Arun Private Sector Housing and Public Health response

From: Chantelle Bashford <Chantelle.Bashford@arun.gov.uk>
Sent: 27 October 2025 15:14
To: Planning.Responses <Planning.Responses@arun.gov.uk>
Subject: RE: Planning Consultation on: BR/157/25/PL

Application No: BR/157/25/PL

Site Address: 3 & 4 Queens Square Bognor Regis PO21 1SA

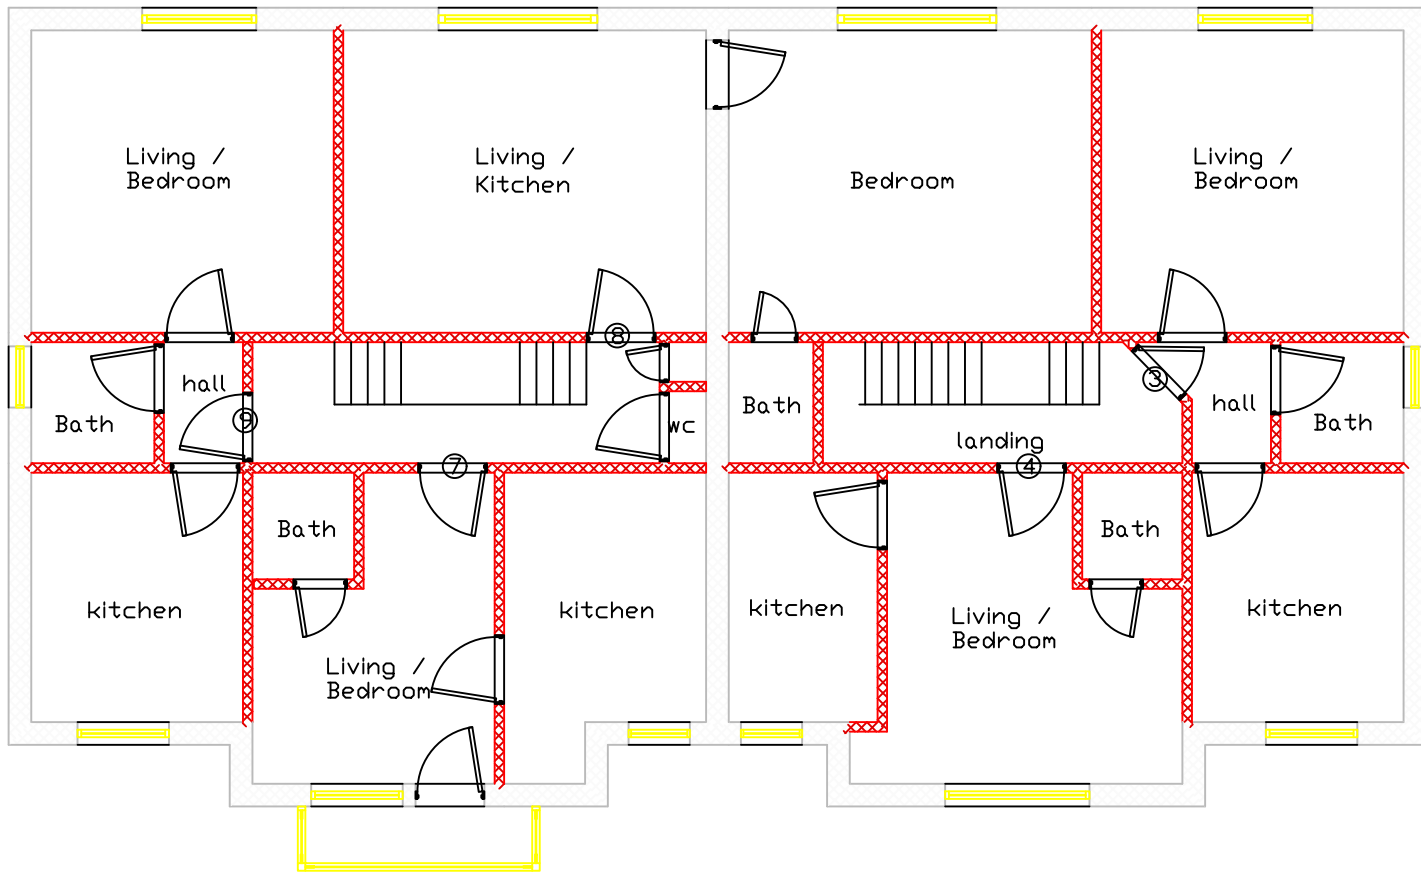
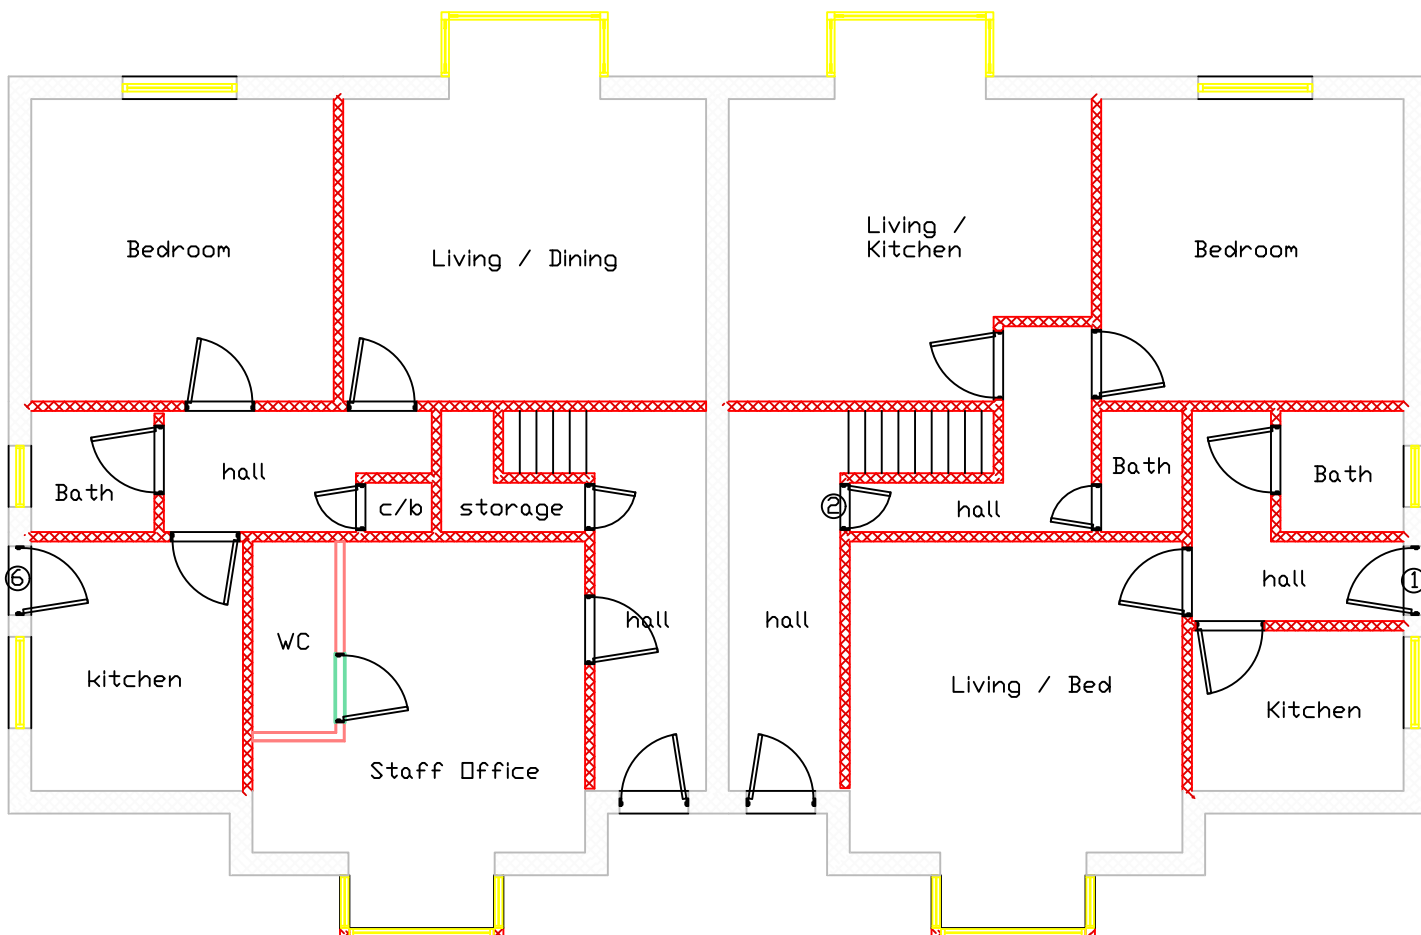
It is noted that room measurements have not been provided on the proposed floor plans therefore I am unable to provide any comment as to whether the room sizes are appropriate.

Flat 6

- Escape window installed to either the bedroom or living/dining room to provide an alternative means of escape;
- FD30S door fitted between the kitchen and hall; and
- Smoke detection installed to the outer room – as the outer room is a kitchen, liaise with a fire alarm engineer for best placement to avoid false alarms from cooking. If this cannot be overcome, an alternative could be to install the smoke detector within the hall and remove the smoke seals from the kitchen fire door, but you must liaise with a competent fire risk assessor in the first instance for their comments

Flat 8

- Escape window installed to the bedroom to provide an alternative means of escape;
- FD30S door fitted between the living/kitchen and bedroom; and
- Smoke detection installed to the outer room – as the outer room contains a kitchen, liaise with a fire alarm engineer for best placement to avoid false alarms from cooking. If this cannot be overcome, an alternative could be to install the smoke detector within the bedroom and remove the smoke seals from the bedroom fire door, but you must liaise with a competent fire risk assessor in the first instance for their comments

Whilst measures can be implemented to overcome the inner room scenarios, consideration should be given to reconfiguring the layout of the flats in question to prevent inner rooms.

- The proposed bathrooms within flats 5 & 10 do not appear to be of an appropriate size and/or layout to provide adequate space for the user. From the proposed plans, the bathrooms appear very narrow and compact, increasing the likelihood of the users colliding with the walls and/or amenities around them. It is possible this could be identified as a “Collision” hazard under the Housing Health and Safety Rating System (HHSRS), therefore consideration should be given to reconfiguring both bathrooms
